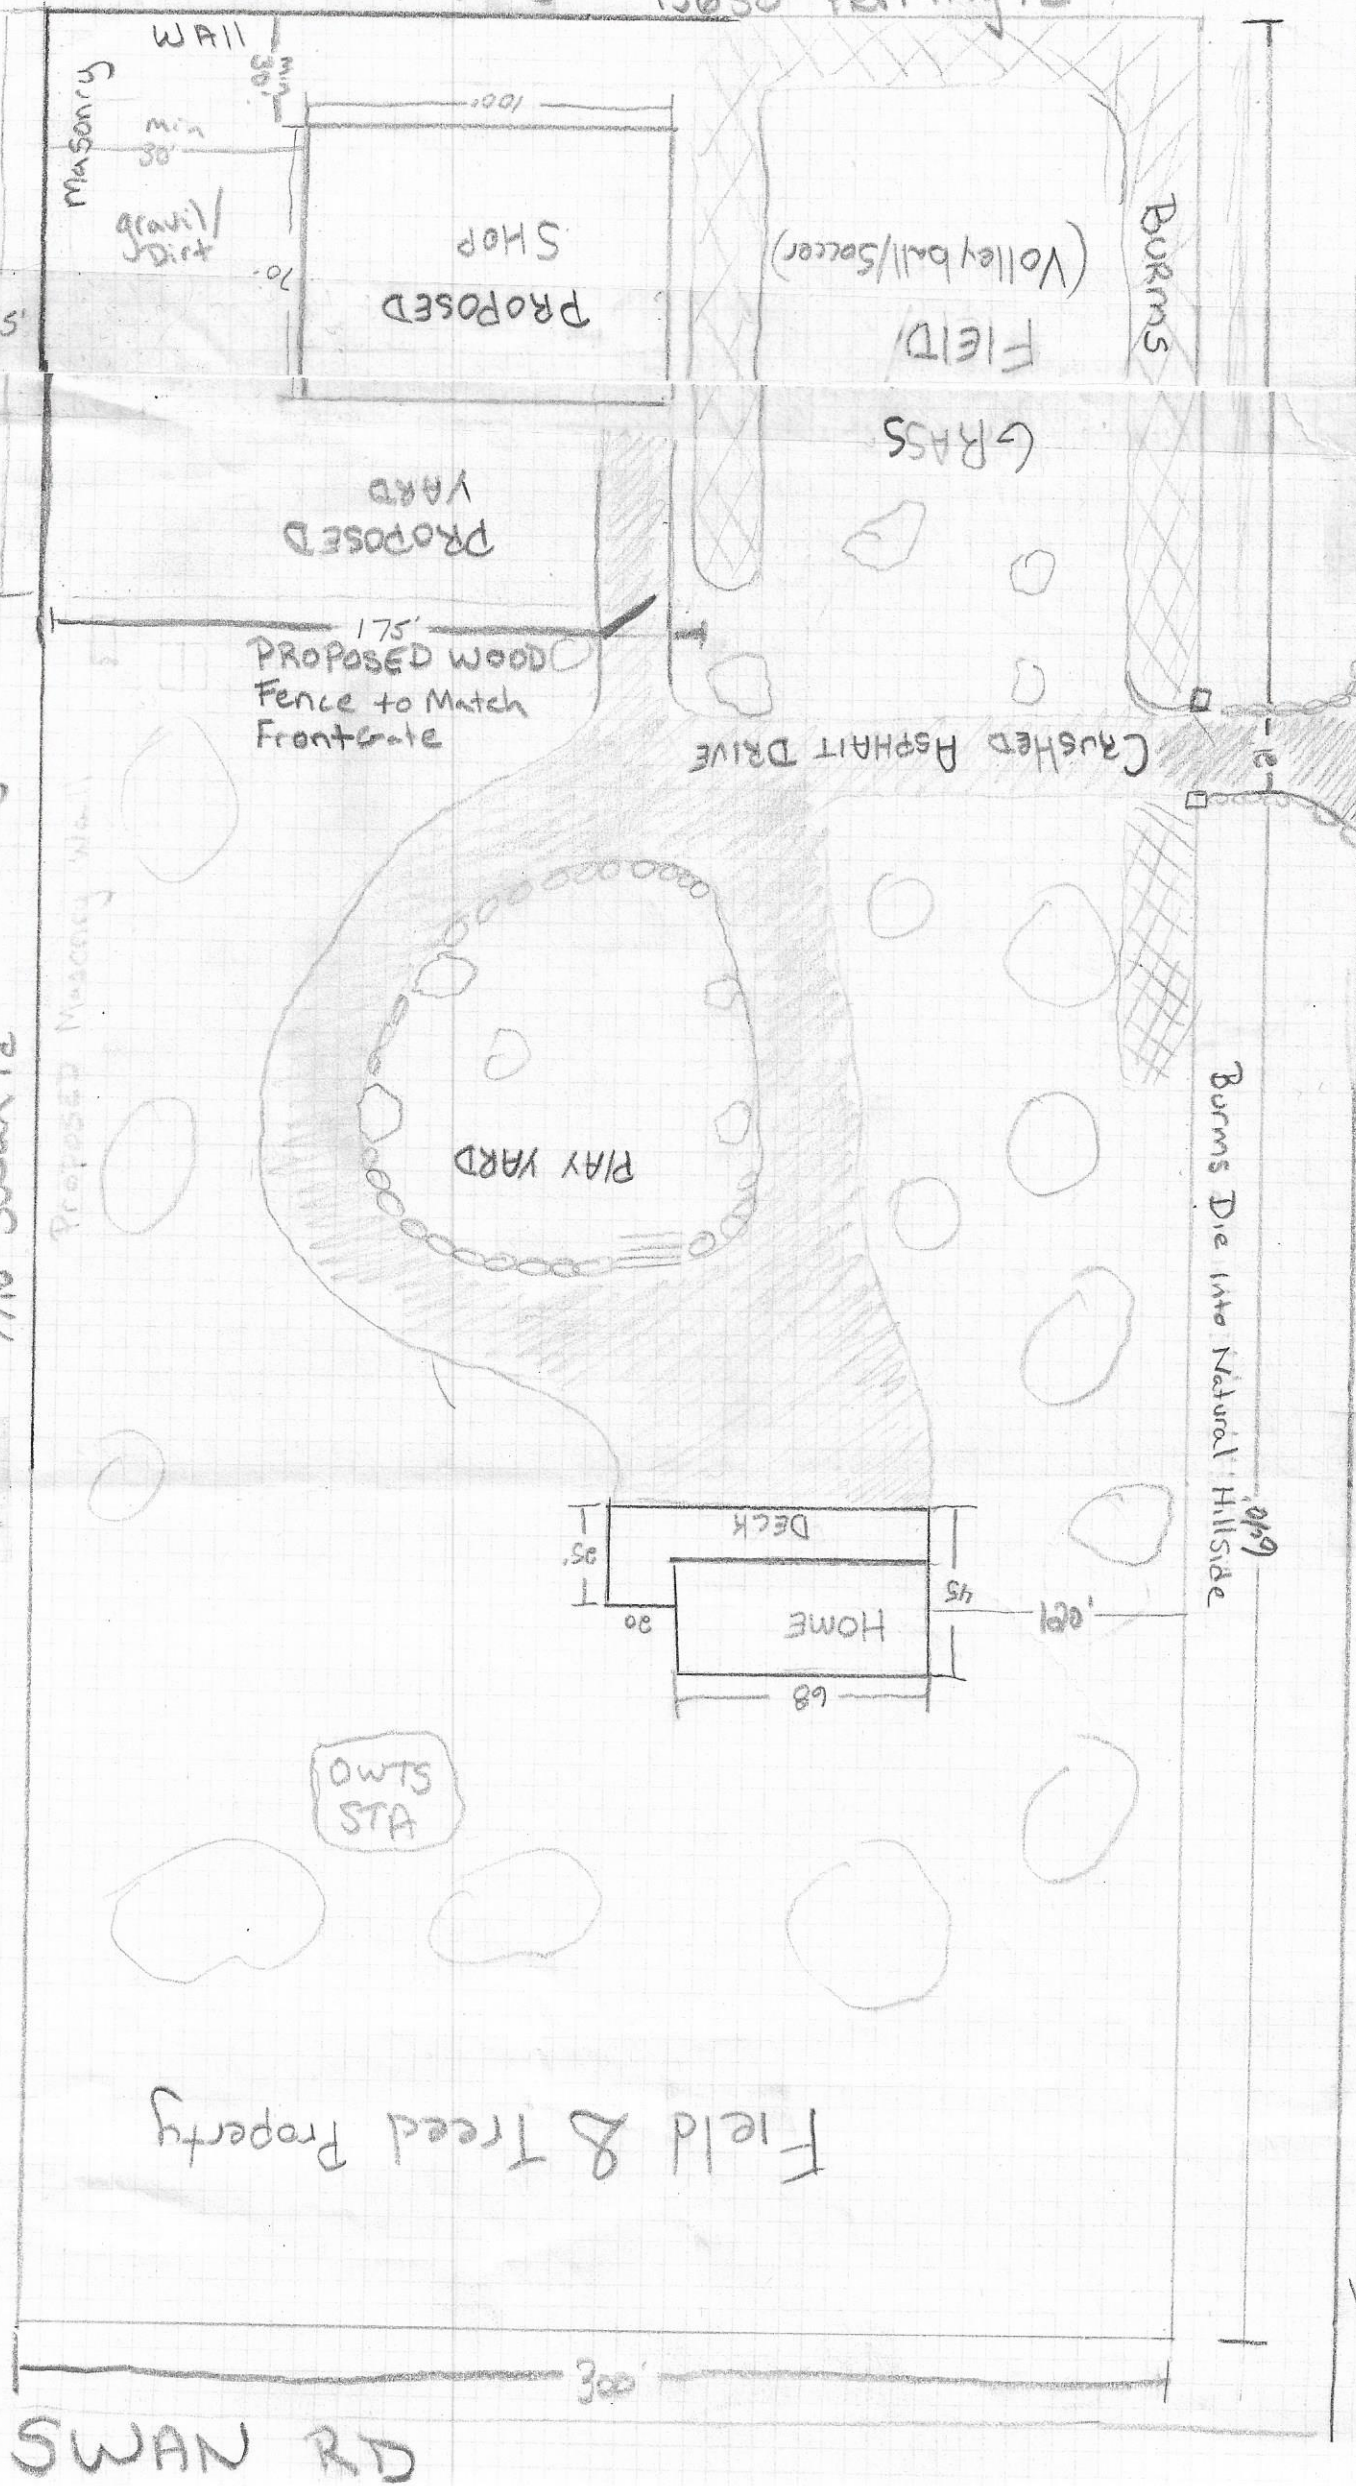
Identify the surface type of the proposed yard. Dirt, gravel, paved?

property lines must be depicted with measurements from the property lines to any structure or outside storage area.

Show the distance from all structures to the closest lot line.

Show all adjacent property owners based on the El Paso County Assessors information.
